### **CITY OF MERCER ISLAND**

#### Pre-Application Meeting (PRE20-038)

Site Location:	9820 SE 35 <sup>th</sup> PL							
Lot Size:	21,700s	f	Zoning:	R-9.6 (Single Family)				
Brief Project Description:	:		Documents Provided:	Easement info, fire gross sf, Geotech report, GIS map, hazard report, narrative & questions, plan set, plat map, and pre-app form.				
Applicant Infor	mation:							
Name:			Email:		Phone:			
Priscilla Wenzel			priscilla@mediciarchitects.com		602-568-5689			
Second Pre-application Meeting Required: Not Applicable			Click for explanation if necessary

SHORT PLAT  
SCALE: 1"=40'

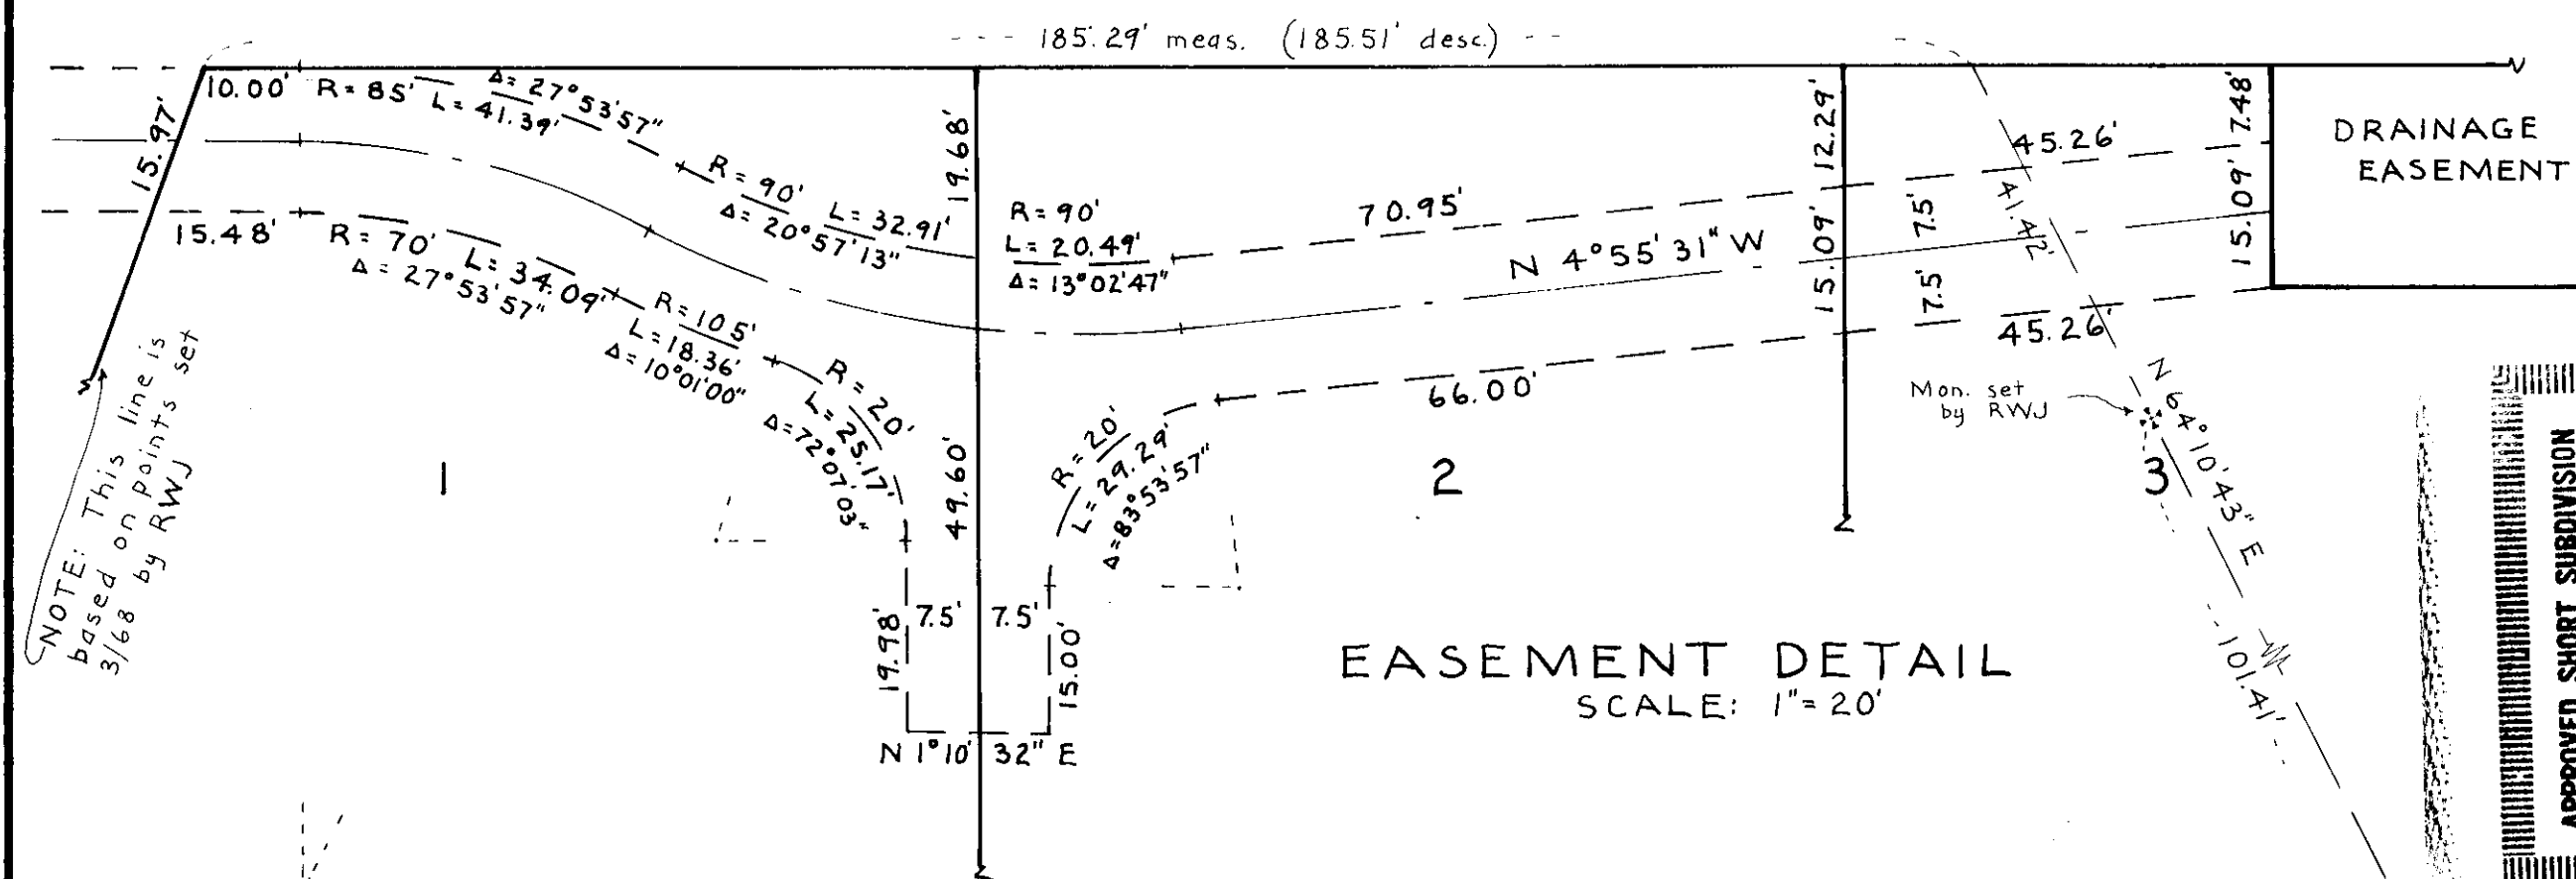
- a. Lauren Anderson (Planning) response: the recorded setbacks on the plat do vest. There was a lot line revision in 1993 under SUB9206-014 please refer to Attachment 1. In 2001 there was the Baker lot line revision under SUB01-009, Recording #20021125900027 refer to Attachment 2.

b. The setbacks that were recorded on the latest subdivision is what the project vests to – thus the side yard setbacks are 10 feet to the south and 5 feet to the north that then becomes 10 feet for the northwest portion – refer to Attachment 2. Please refer to the snippet below:

- 5. Woodson Short Plat
  - a. Official plat map was provided by the applicant in the pre-app materials.
  - b. Easements:
    - i. 15 foot ingress, egress, utility & drainage easement

- ii. 10 foot utility easement
  - c. Designated plat setbacks: these recorded setbacks vest to the property (unless there has been another short plat or plat alteration, which the City doesn't have a record of). This means the front, side and rear yard setbacks are what are shown on the plat map.

- d. Conditions of plat approval on page 1 of 2 of the recorded plat still apply. Most apply for new house construction, but the following may apply to this project: #5, 6, 9, 10, 12, 13.
